WEST SUSSEX COUNTY COUNCIL CONSULTATION

TO:	Arun District Council FAO:A Gardner
FROM:	WSCC - Highways Authority
DATE:	26 April 2021
LOCATION:	71 Beach Road Littlehampton BN17 5JH
SUBJECT:	LU/76/21/PL Sub division of dwelling into 3 No. 2 bed flats. This application may affect the setting of a listed building & is in CIL Zone 4 (Zero Rated) as flats.
DATE OF SITE VISIT:	n/a
RECOMMENDATION:	Advice
S106 CONTRIBUTION TOTAL:	n/a

PROPOSED FLOOR PLANS

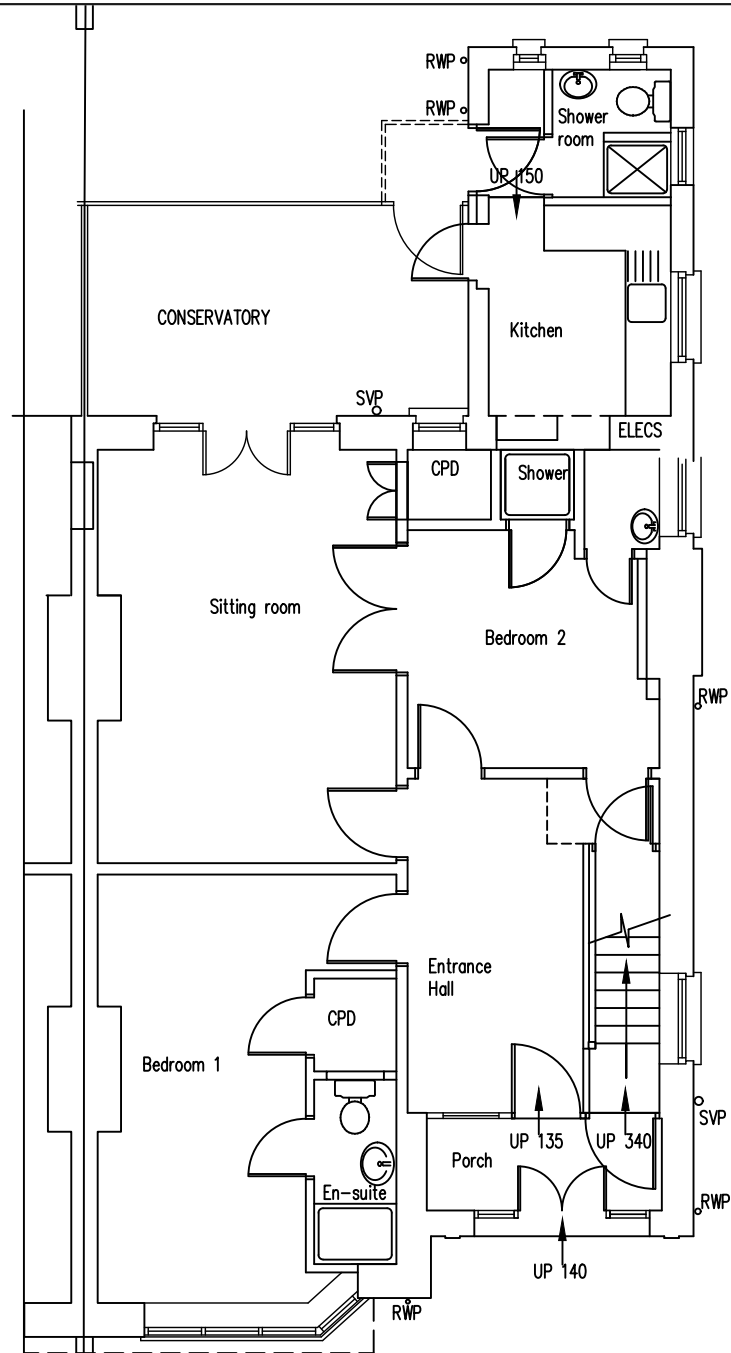
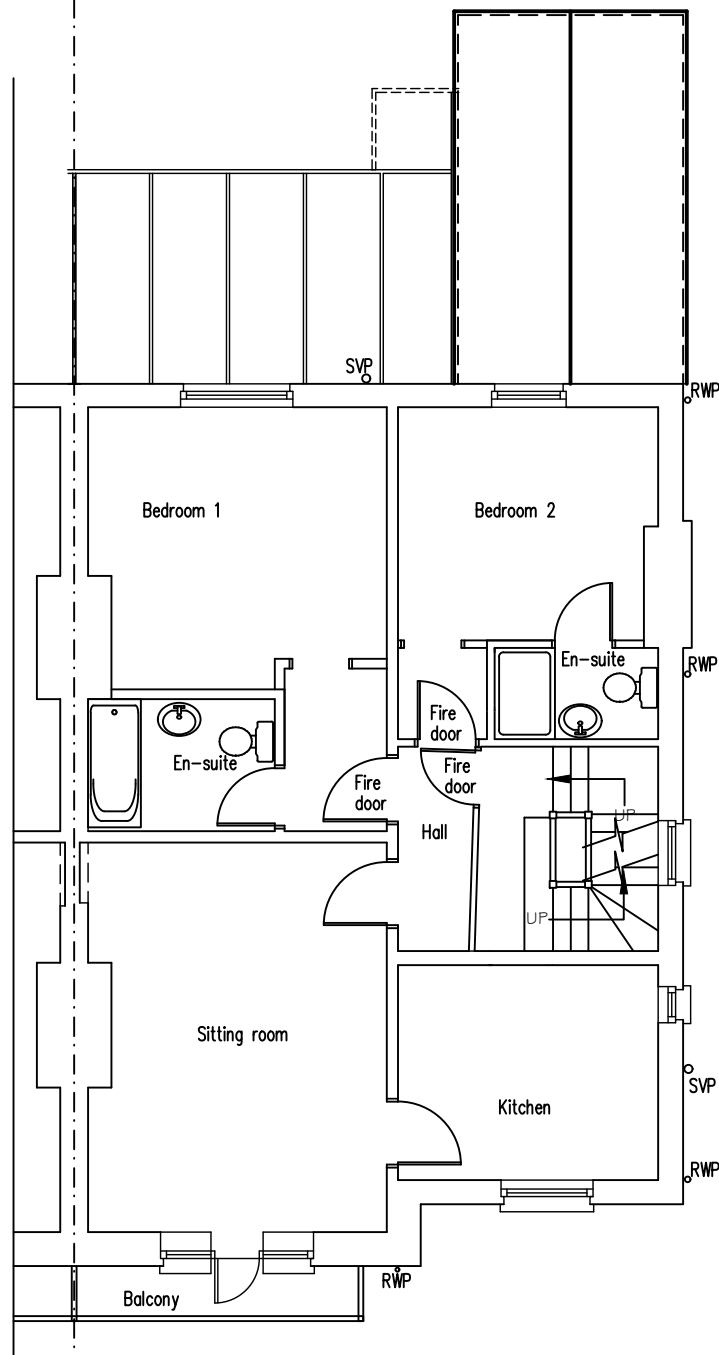
There are no proposed alterations to the existing onsite parking. The WSCC Car Parking Demand Calculator (PDC) would expect 2 parking spaces per dwelling to be provided for this development. While some overspill parking may occur as a result of the proposal the LHA would not anticipate that this could result in a highway safety issue in this location, given the comprehensive parking restrictions prohibiting vehicles to park at places that are detriment to the highways safety. The LPA may wish to assess any implication from an amenity perspective.

In order to promote the use of sustainable transport methods, the LHA recommends that secure and covered cycle parking is provided for the proposed dwellings.

No part of the development shall be first occupied until covered and secure cycle parking spaces have been provided in accordance with plans and details to be submitted to and approved by the Local Planning Authority.
